Consultation Response from KC Highways**2019/91405 71, Woodhead Road, Honley, Holmfirth, HD9 6PP****Outline application for erection of two dwellings****Date Responded: 30/05/19****Responding Officer: JT****Responding Ref: K3-49/50**

This application seeks outline approval for the erection of two dwellings at 71 Woodhead Road, Honley.

DRAWING TITLE
**PROPOSED SITE PLAN INDICATING
EXISTING TREES**

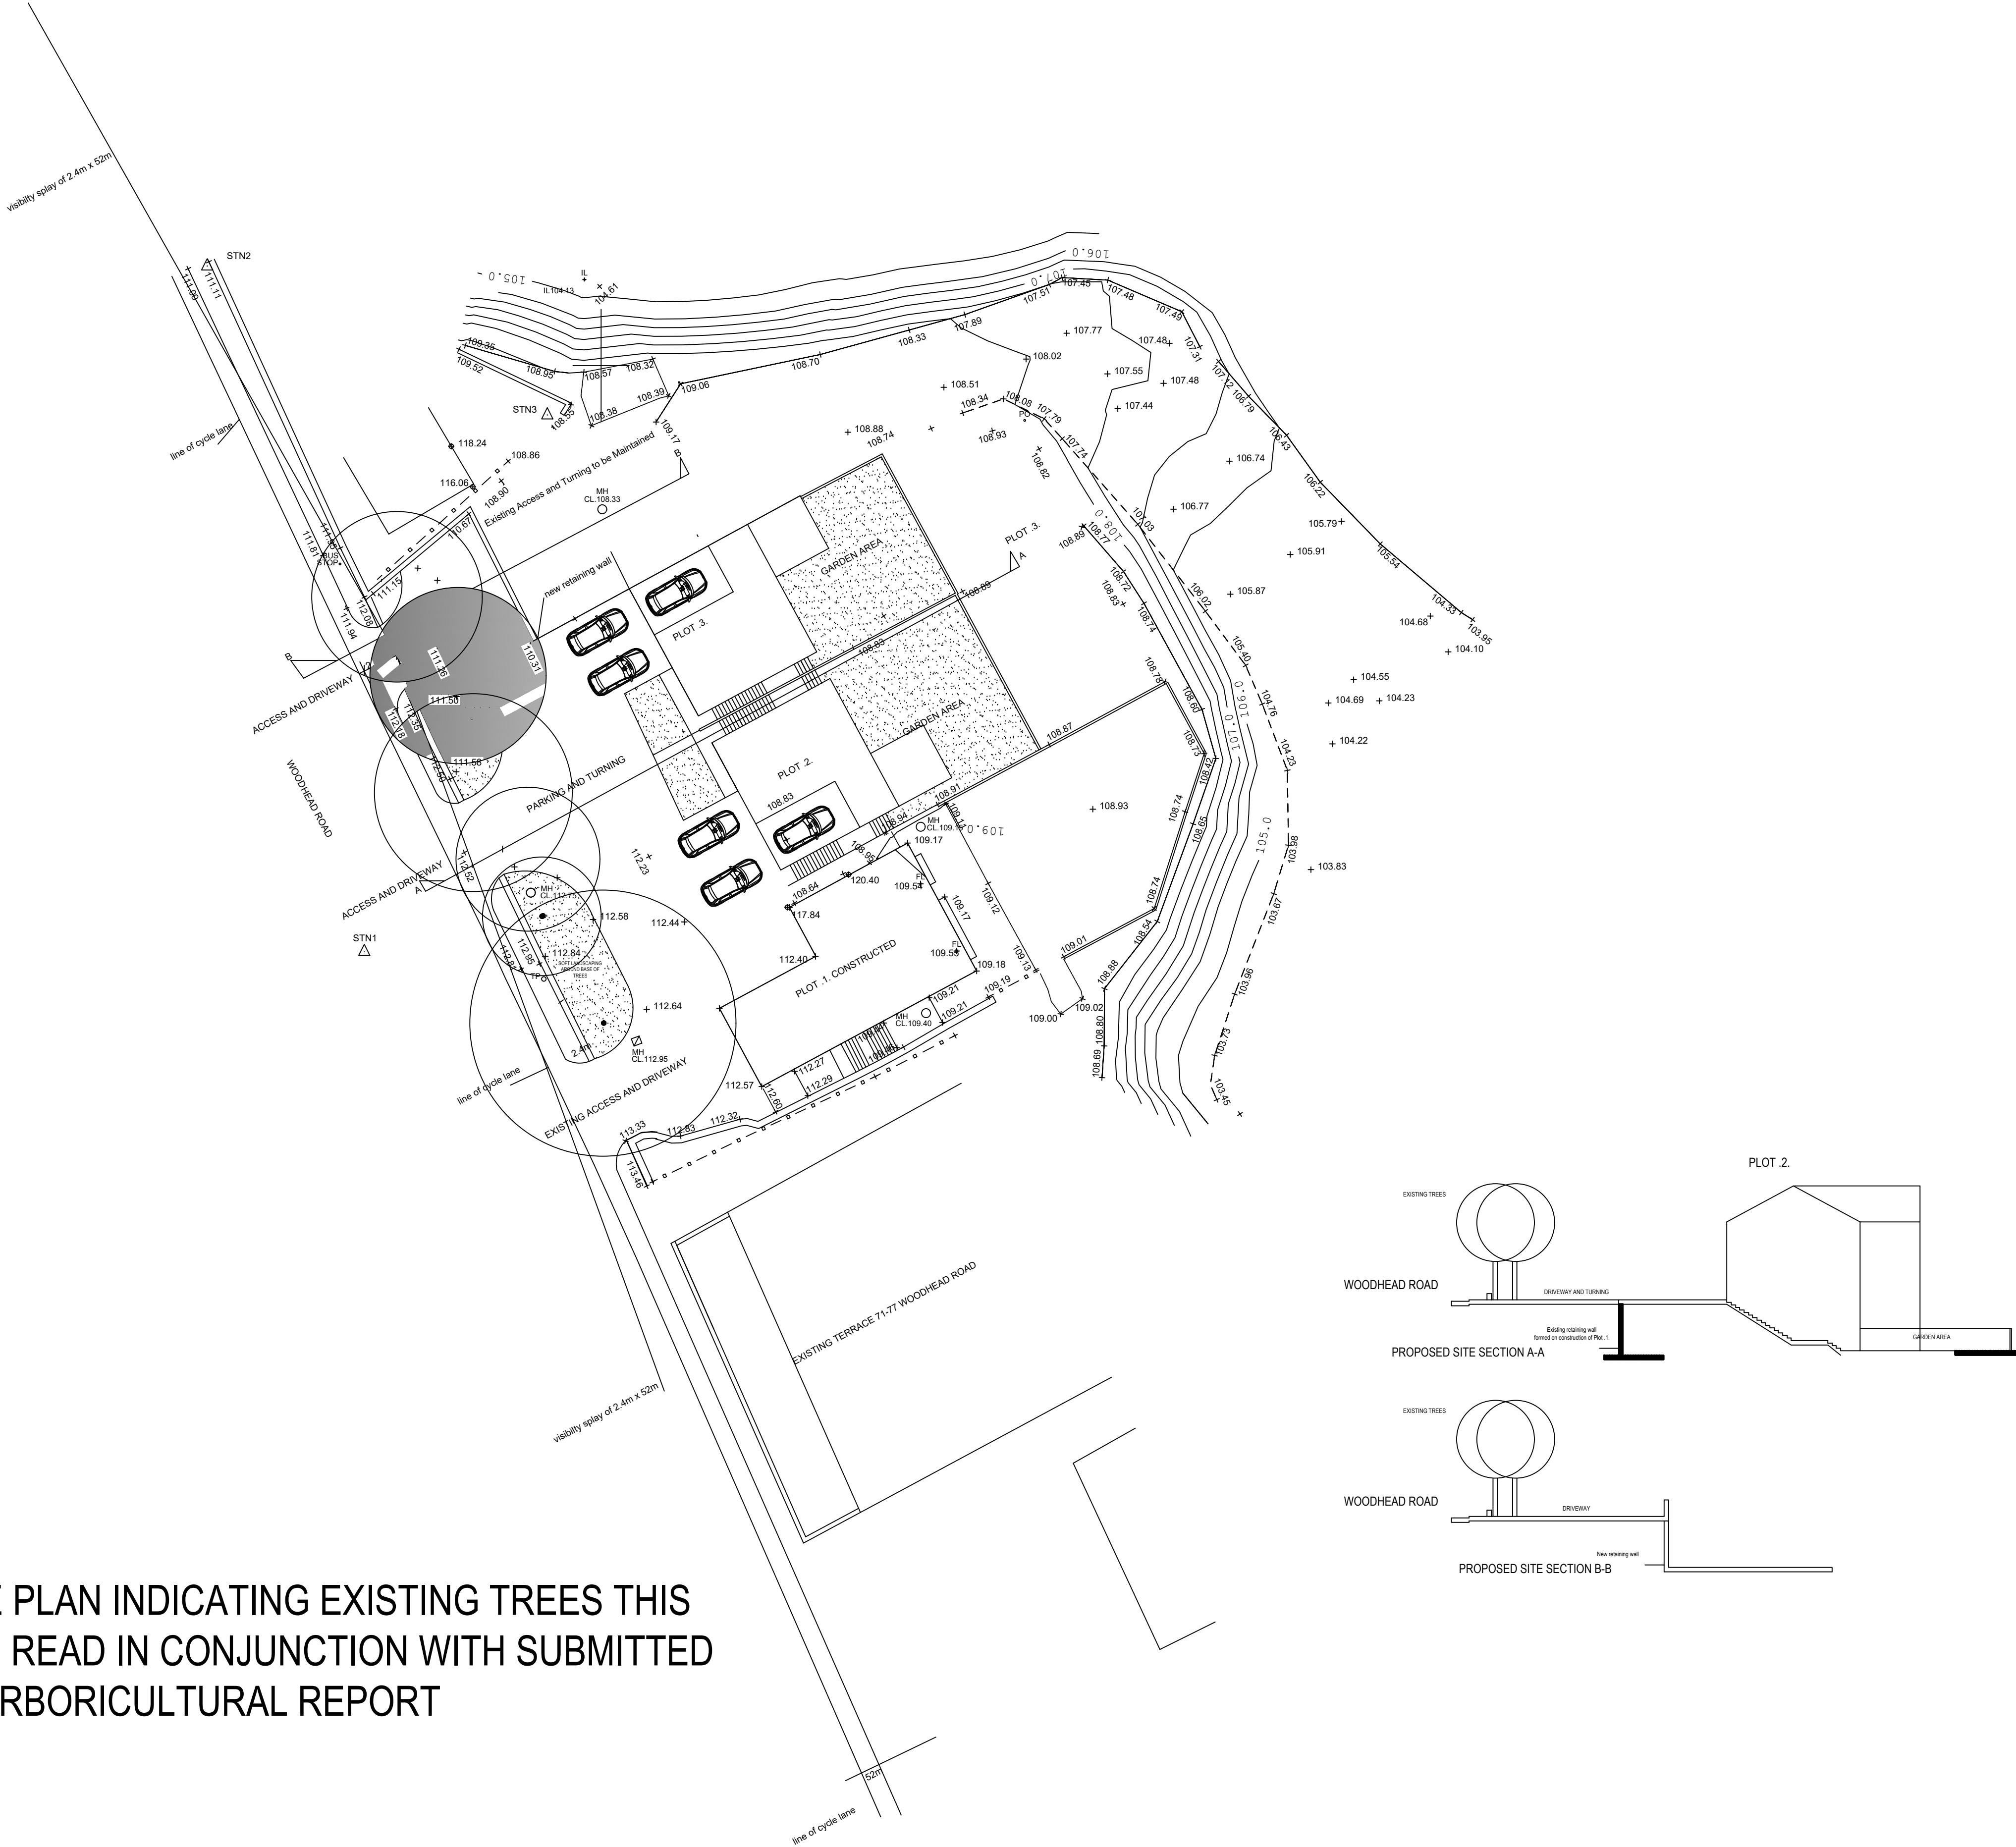
Although the submitted plan only shows sight lines from one of the proposed access points, the two accesses were pinpointed on-site and sight lines were demonstrated to the Highways DM officer at this time.

Whilst it is likely that the application would be acceptable from a highways perspective, please ask the applicant to provide:

- Visibility splays from each access dimensioned on a plan.
- Details of footway provision for the full frontage of the site demonstrated and dimensioned on a plan.
